**Hurlstone Agricultural High School (Hawkesbury), Richmond,
Western Sydney University Campus, 2 College Street, Richmond (SSD 8614)
Notice of Exhibition**

TAB A – Detailed Comments on State Significant Development Application

DRAWING  
**Master Plan - Site**

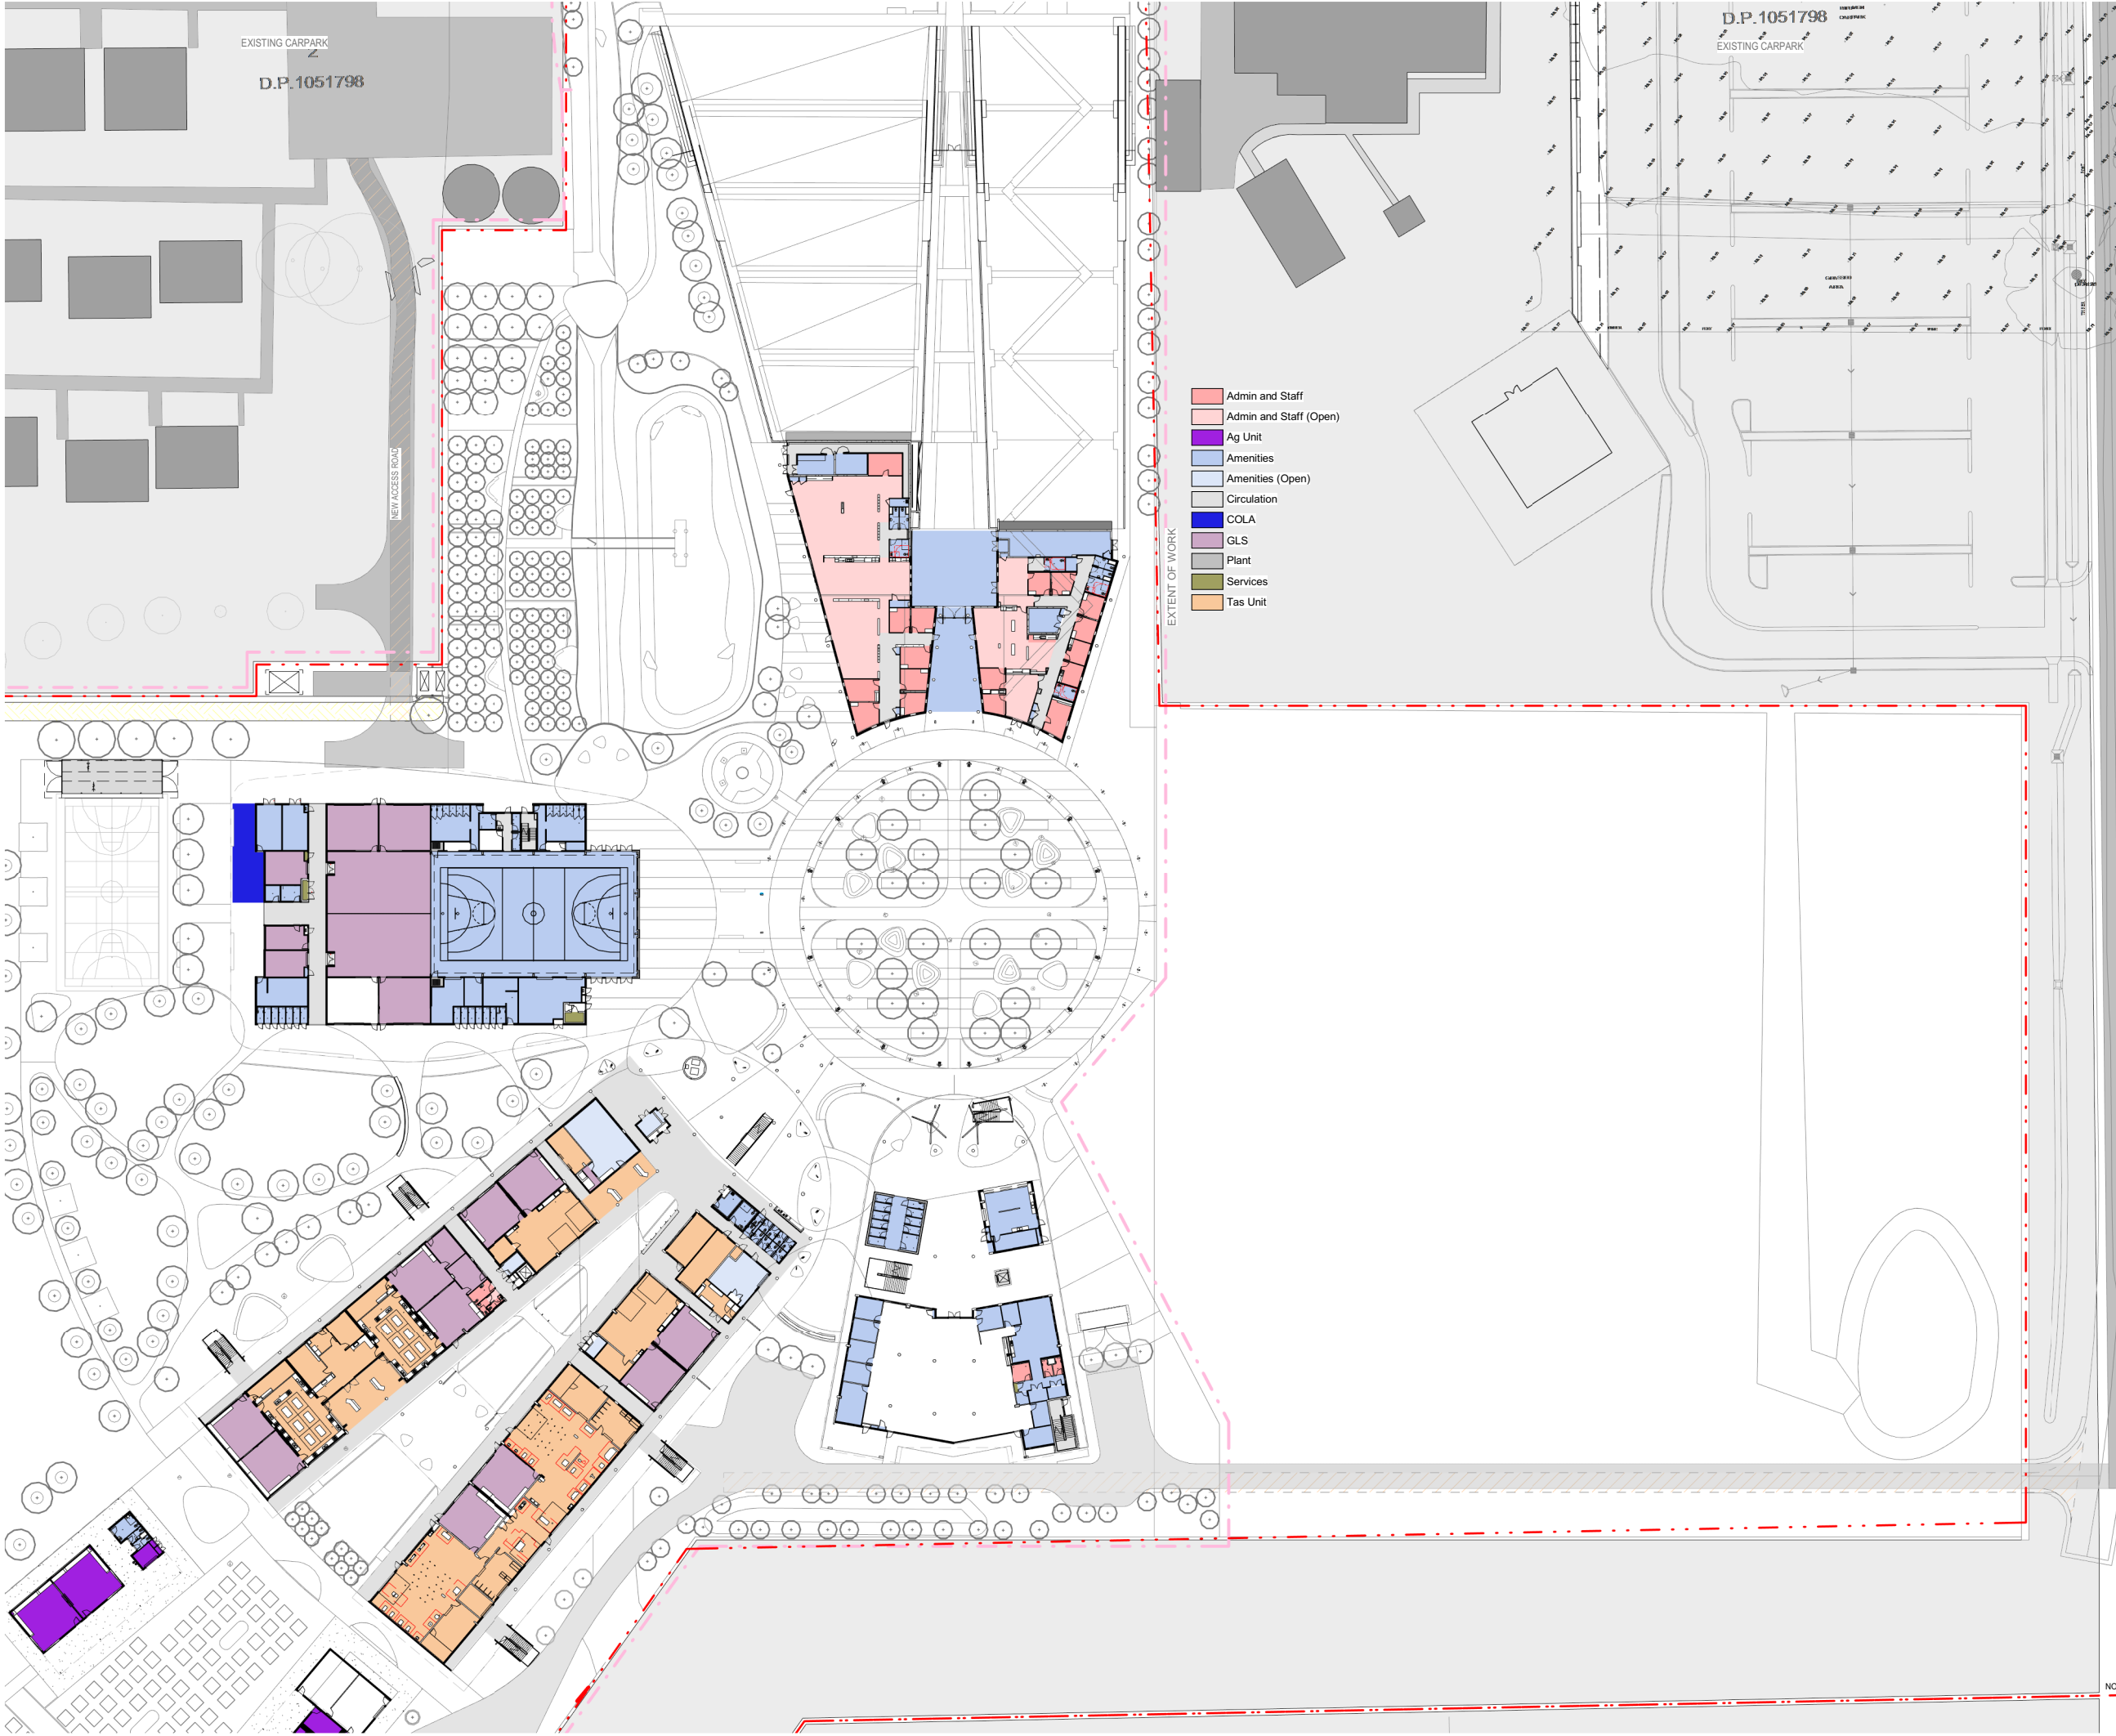
Section 3.7.2 of the EIS mentions the provision of approximately 75 bicycle parking spaces, however the Architectural Drawings in Appendix C does not clearly identify the proposed locations.

The Architectural Drawings should include the location of the proposed bicycle parking. Bicycle storage facilities should be designed in accordance with *AS 2890.3: Parking Facilities for Bicycle Parking (2015)* and Austroads Guidelines. This can be achieved by locating bicycle parking and end of trip facilities in secure, convenient, accessible areas which are close to main entrances and away from vehicles access, incorporating adequate lighting and passive surveillance.
